Erection of a first floor front/side extension, two front and two rear dormers to facilitate a loft conversion.

Amendments Summary

To Luton Council
Planning department
Your ref: FZAFFA/24/00158/FULHH

01 FRONT ELEVATION- PROPOSED
GA-202 SCALE 1:50

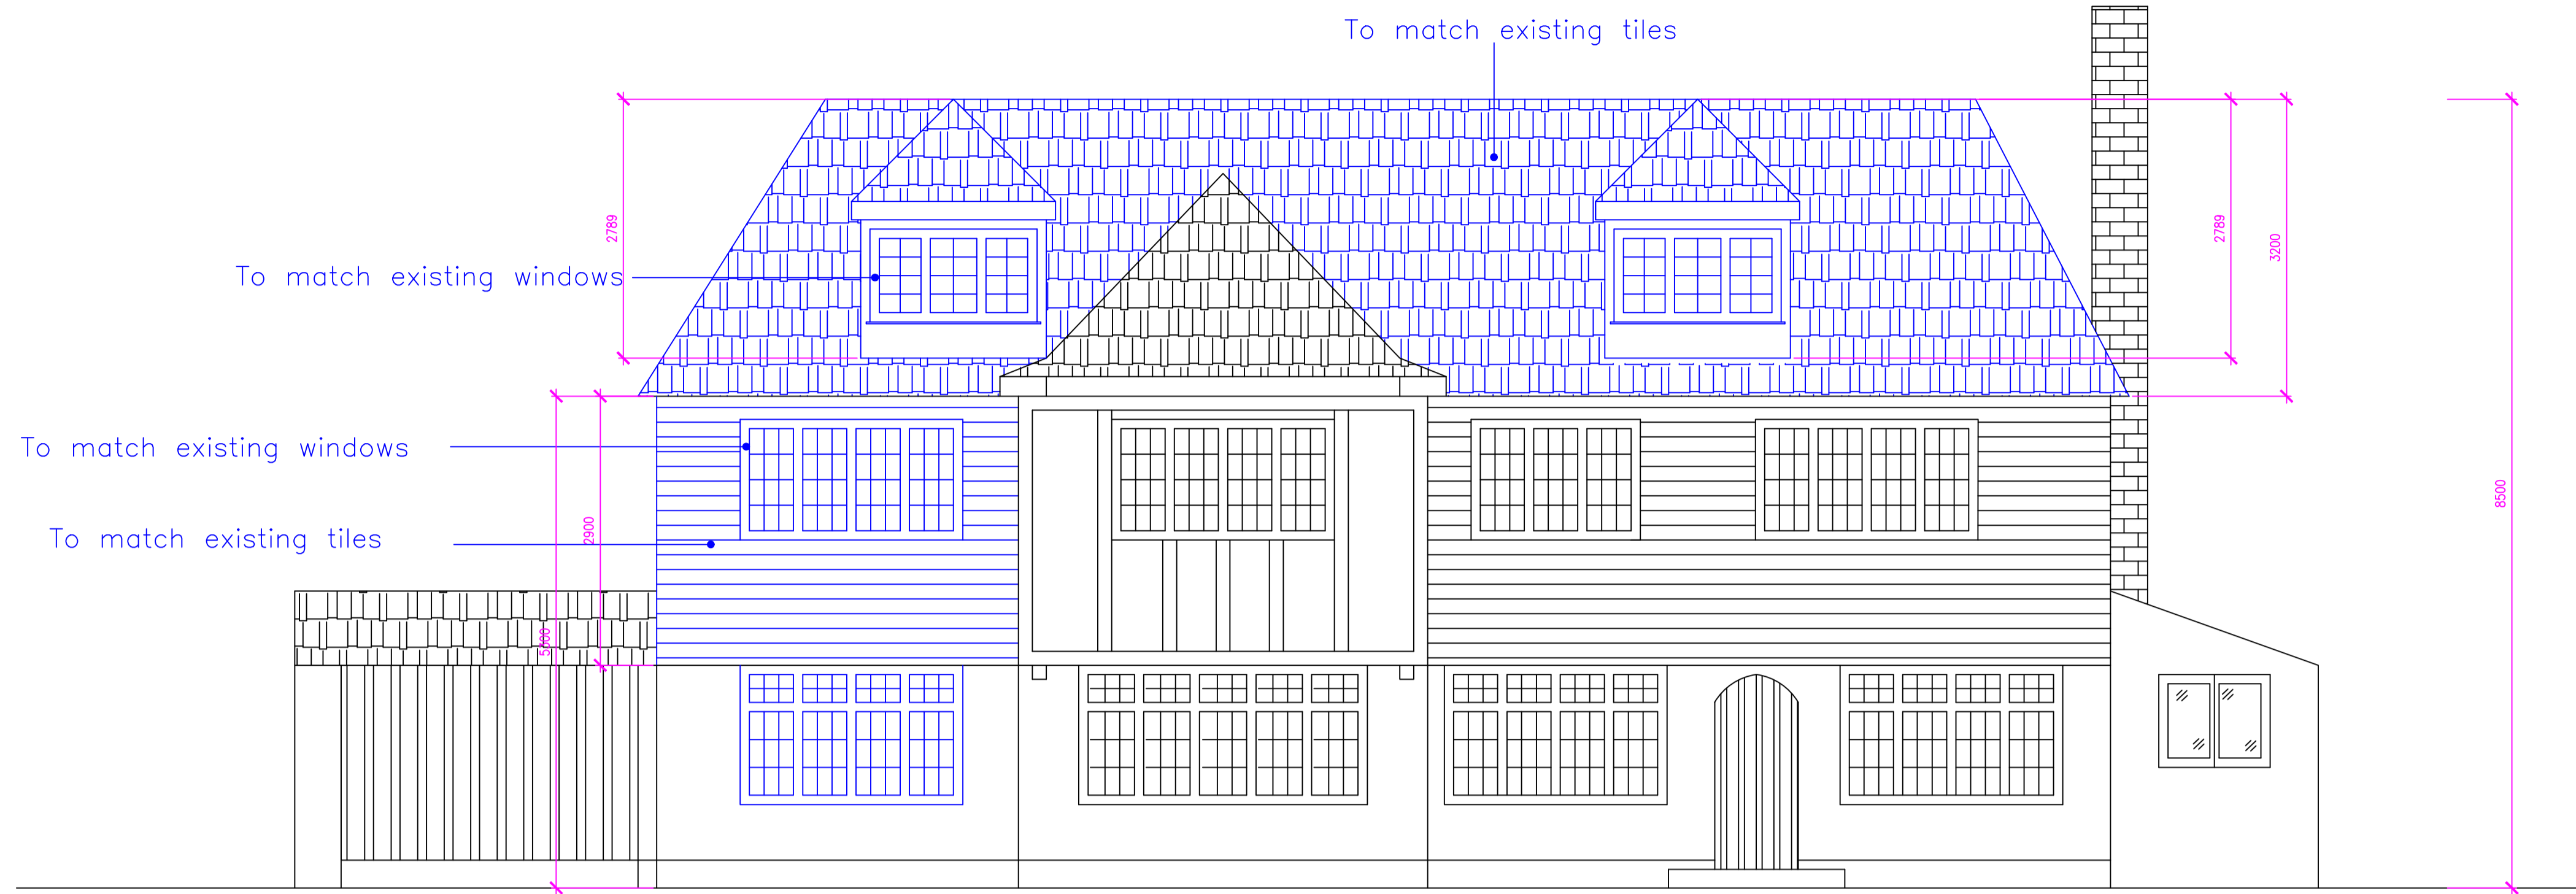
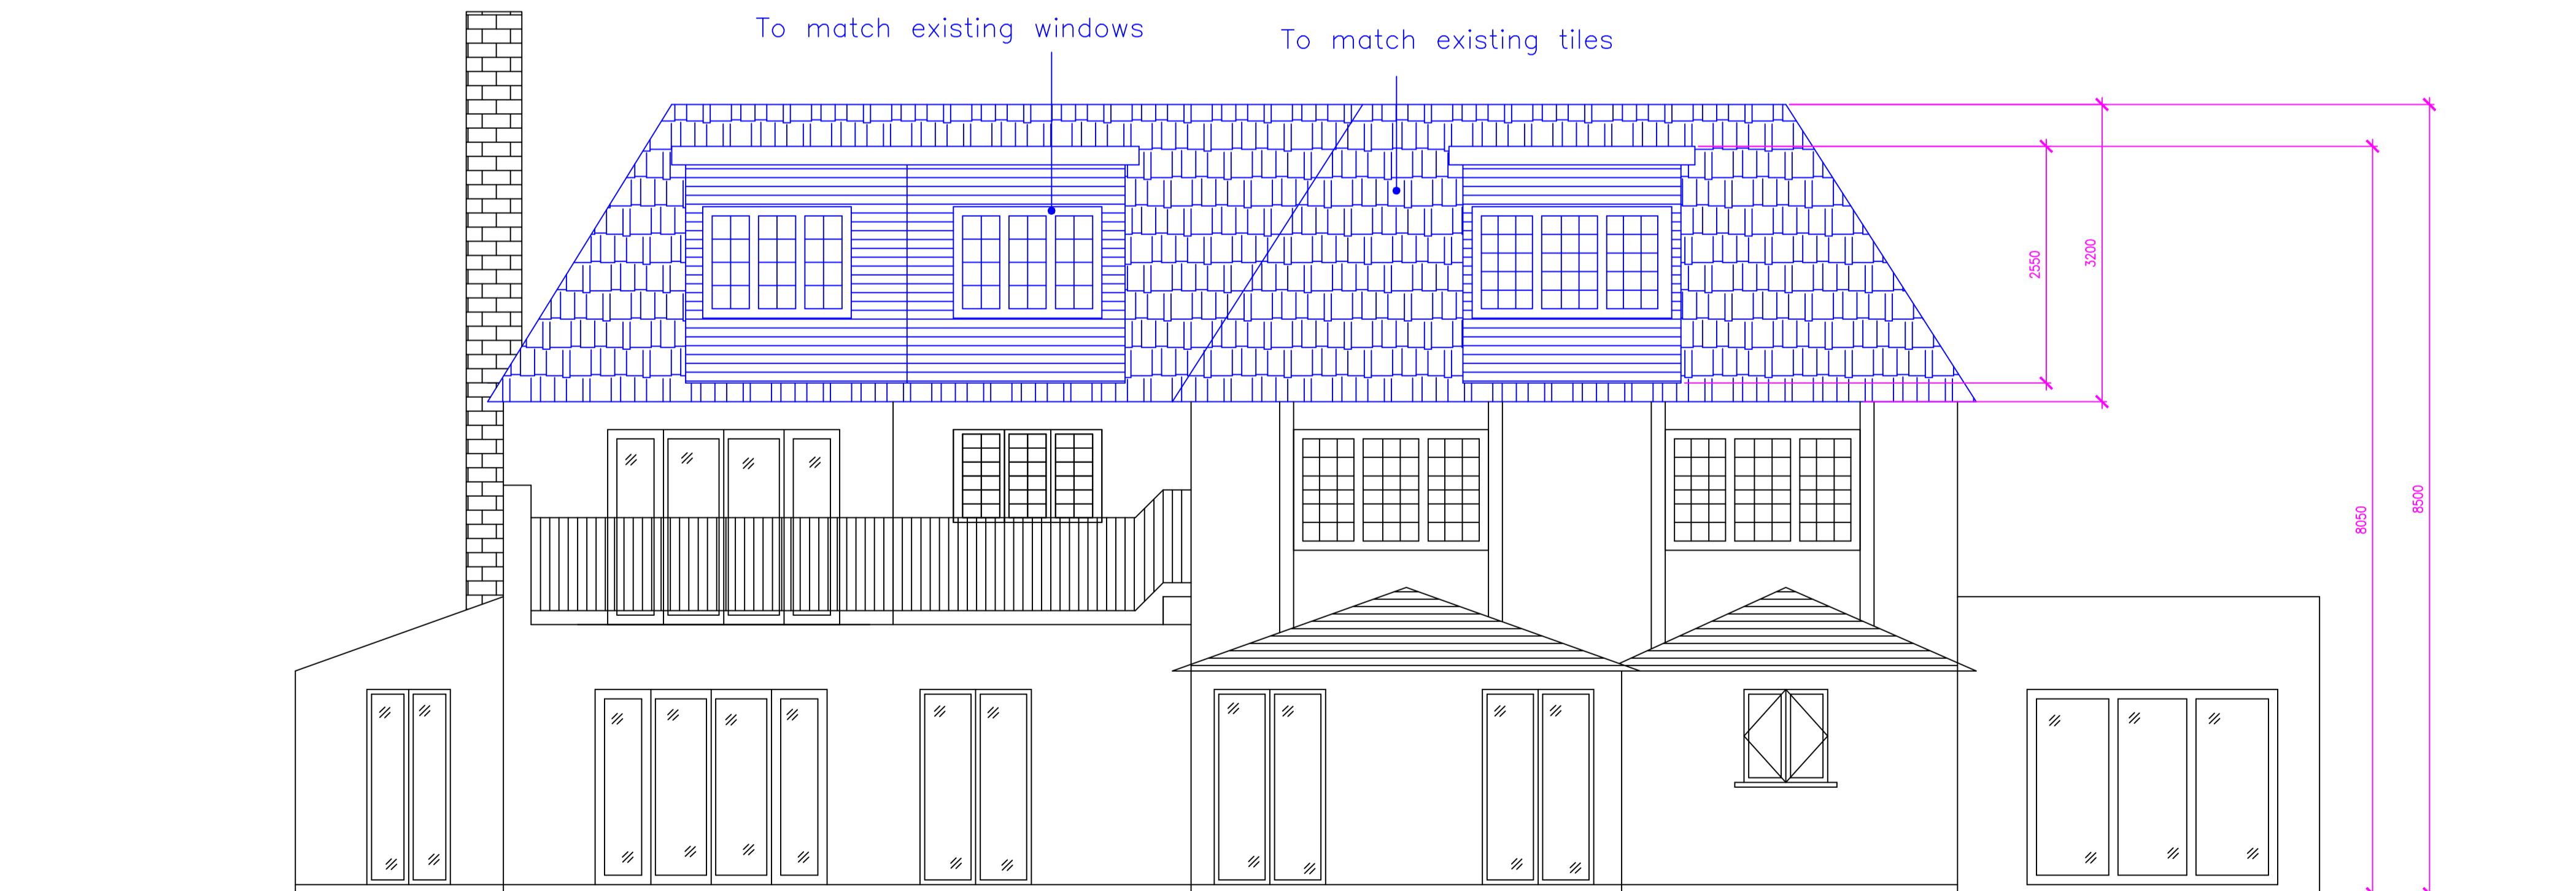
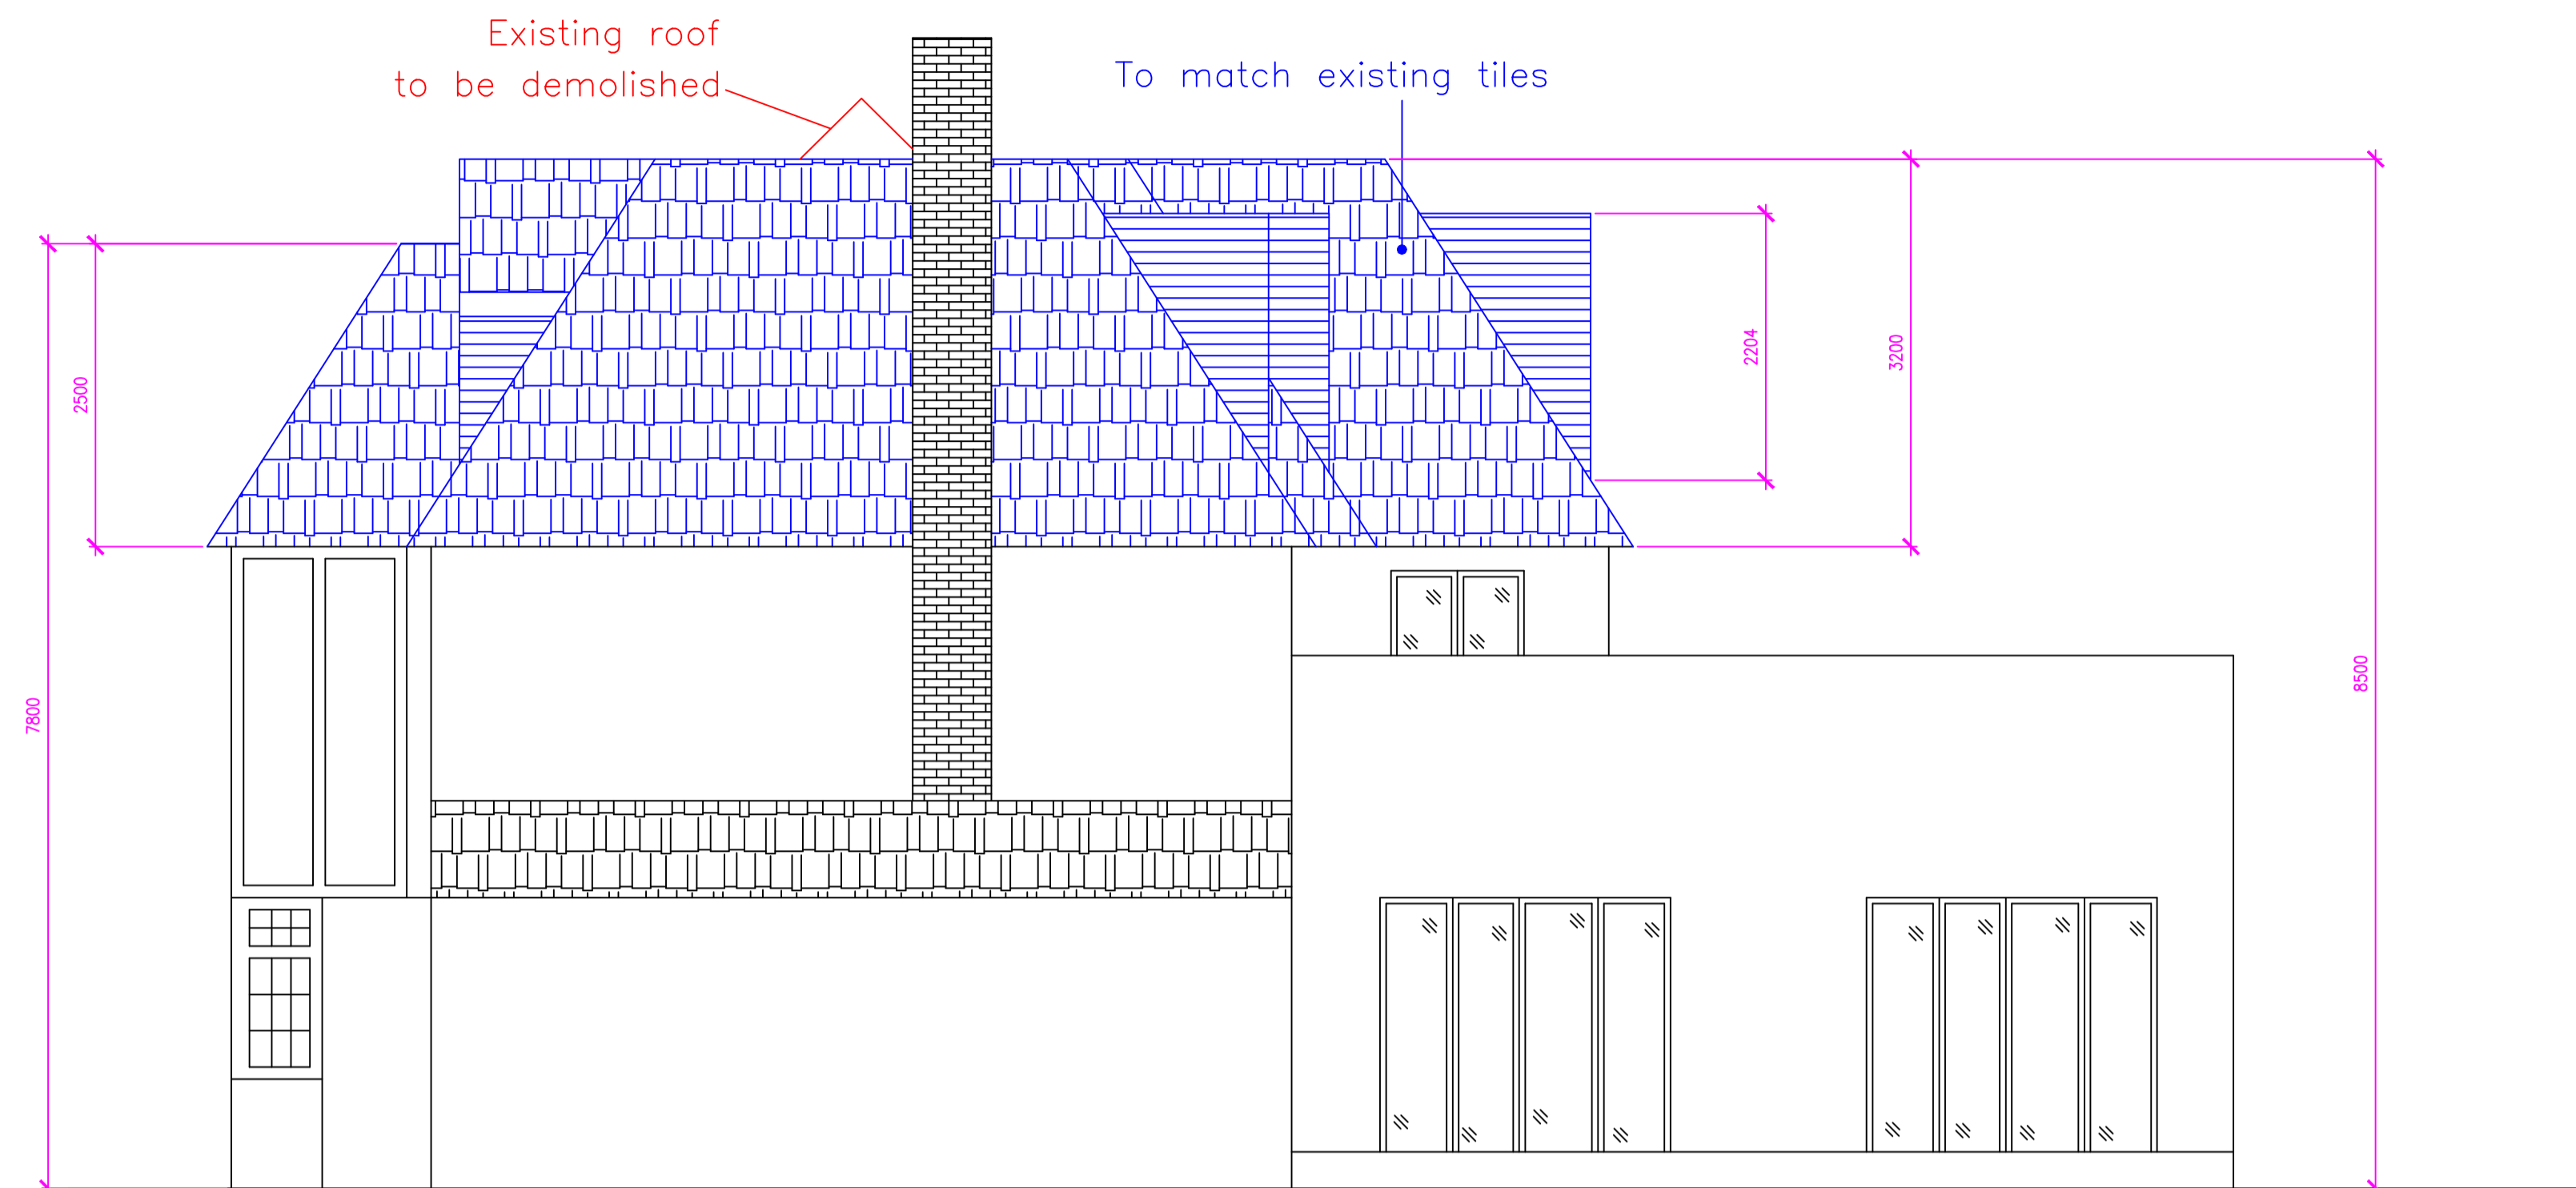
2) Please supply full external height dimensions of the first floor extension and full external dimensions of the front and rear dormers.

New drawings supplied with dimensions.
